**KIRKLEES METROPOLITAN COUNCIL
INVESTMENT & REGENERATION SERVICE**

**DELEGATED DECISION FOR APPLICATION FOR CERTIFICATE OF
LAWFUL DEVELOPMENT**

Reference no.: 2023/CL/91351/W

Site: 108, Penistone Road, Waterloo, Huddersfield, HD5
8RN

Proposed Elevations

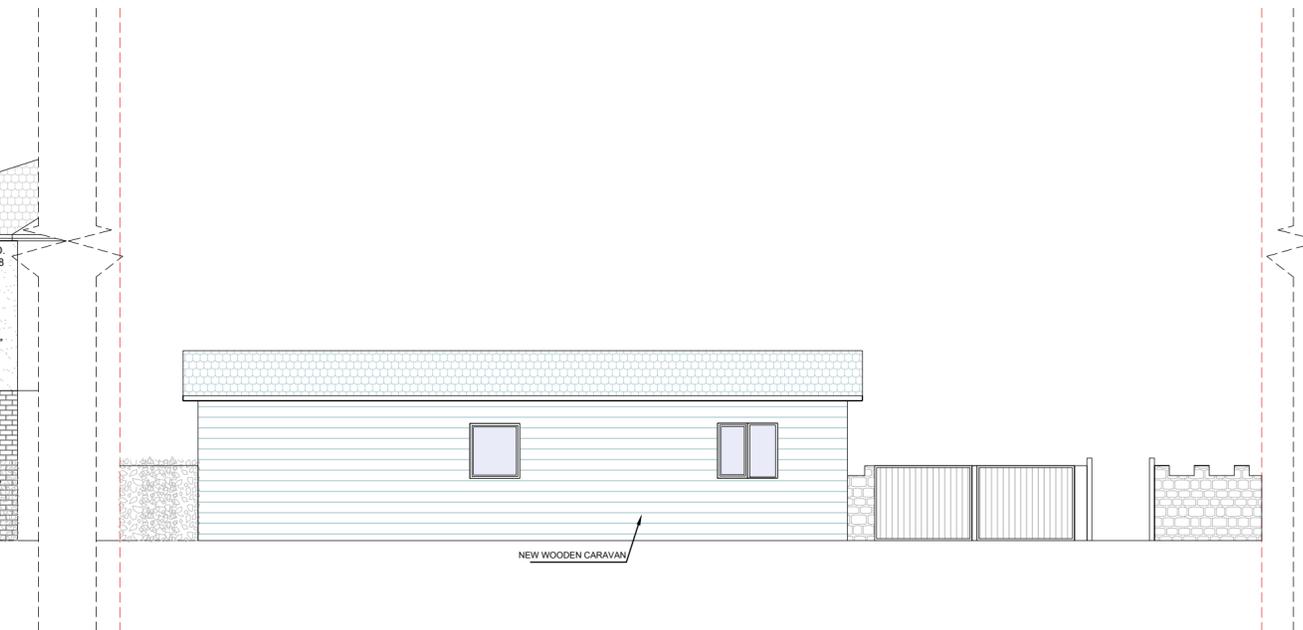
9.13 As no planning permission from the Local Planning Authority exists for the building it may only benefit from a general planning permission under the provisions of the Town and Country Planning (General Permitted Development)(England) Order 2015(as amended) if the relevant limitations are met under Class E of the Order. In this instance the building would fail on sub-paragraphs (c), (e) and (f) in that the building is forward of the principal elevation of the dwellinghouse and over 2.5 metres in height.

Drawing Name	
Proposed Plans	
Project Address	
108, Penistone Road, Waterloo Huddersfield, HD5 8RN	
Scale	Date
1/100 at A2	17.07.2023
Designer	
DG	V2
Drawing No.	
108PenistoneRd_ ProposedPlans_V2

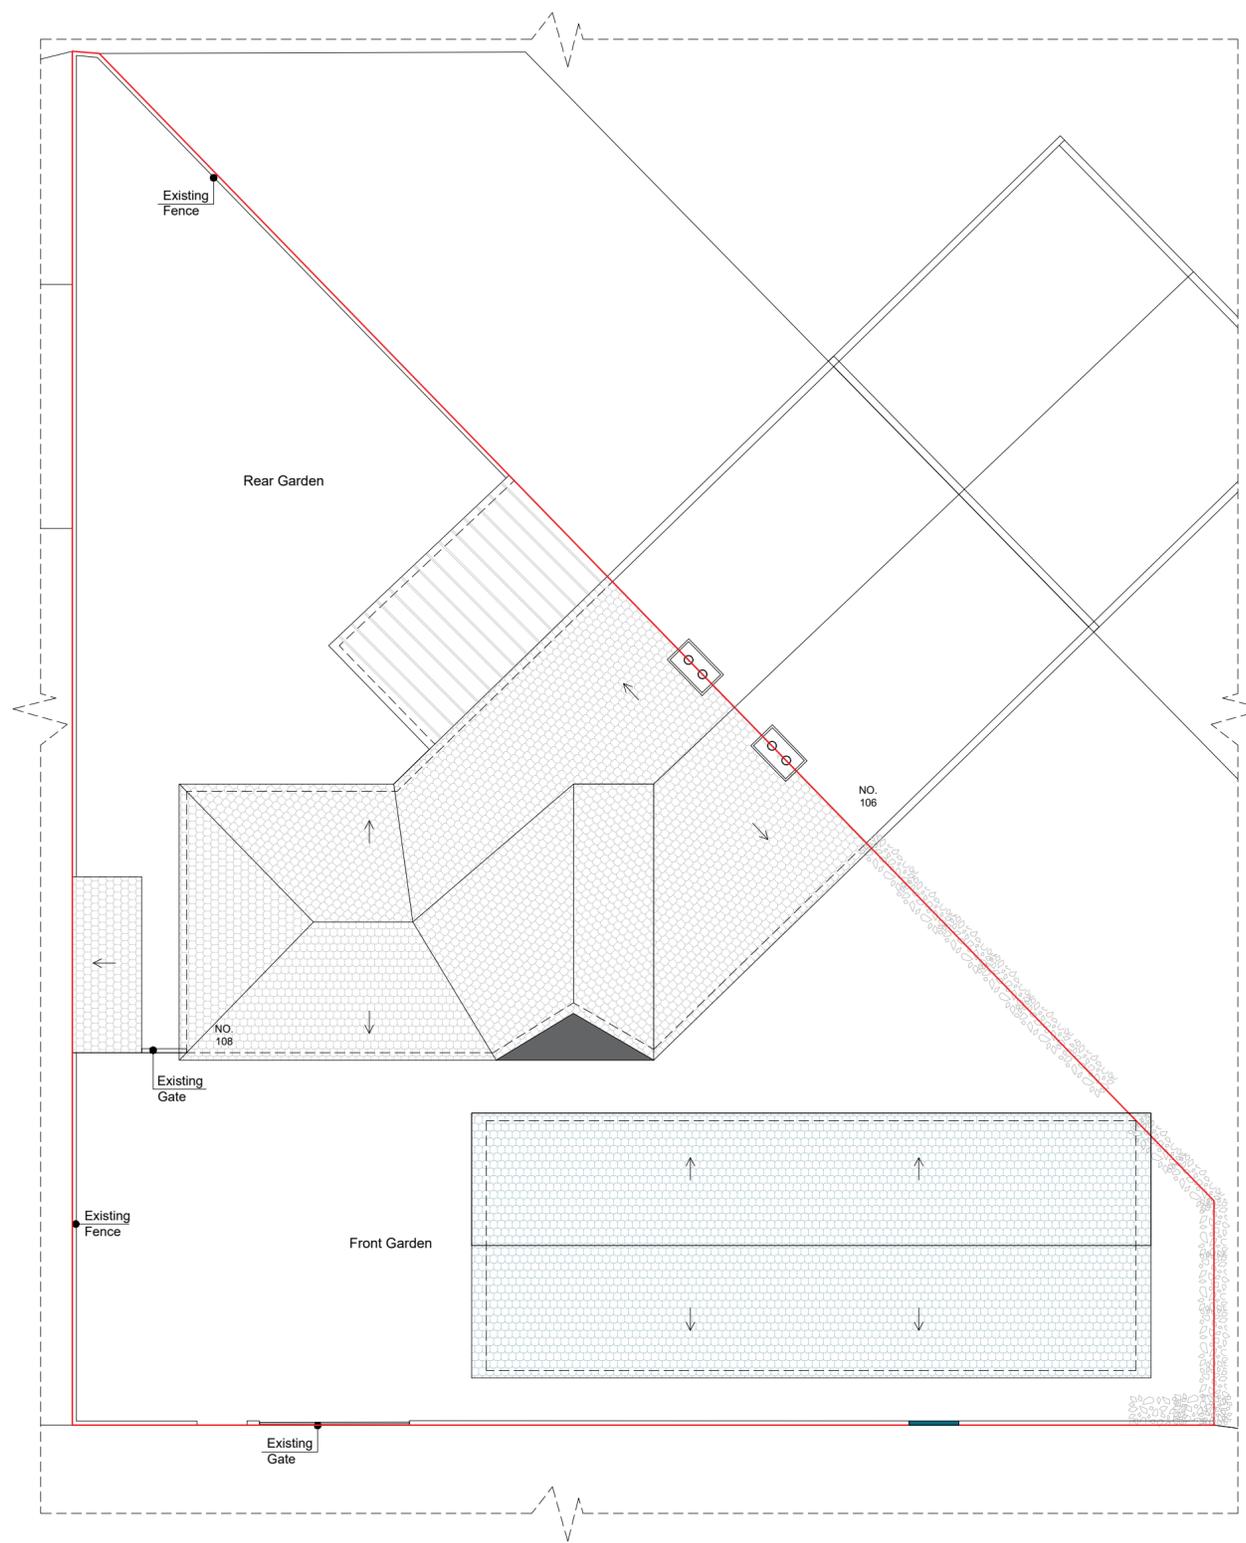
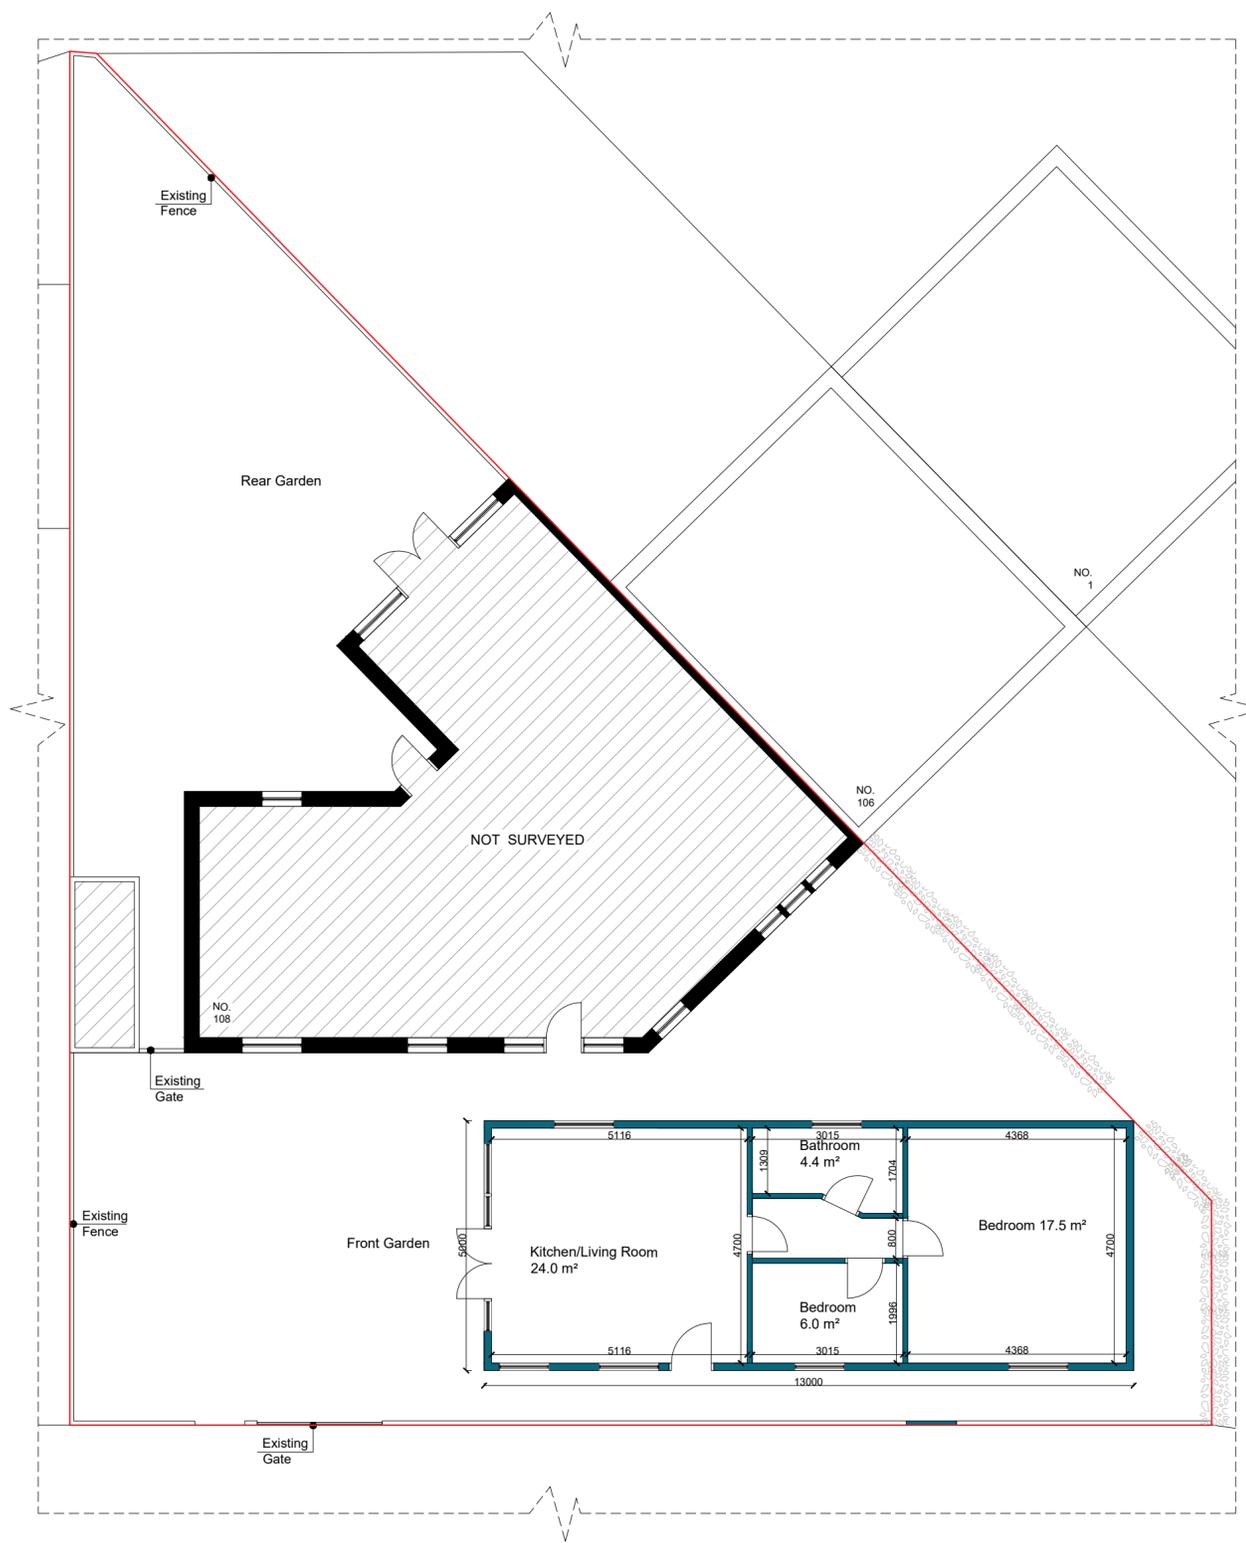
9.15 It is well established that a building under Class E cannot provide primary living accommodation. The applicant states the building is for residential accommodation for family members and floor layout clearly shows the building to consist of a kitchen/living room, two bedrooms and bathroom. This is considered to go beyond incidental and/or an ancillary use to the adjacent dwellinghouse. The building is capable of comfortable independent separate living accommodation without reliance on the dwellinghouse. While it is stated the occupants would share meals at the dwellinghouse, the independence of the building including openings in the boundary wall to allow separate access appears to result in the corner of the existing garden being used to for independent residential use. It is considered the erection of the structure amounts to a functional and physically separate residential unit thus resulting in a material change of use of the land.
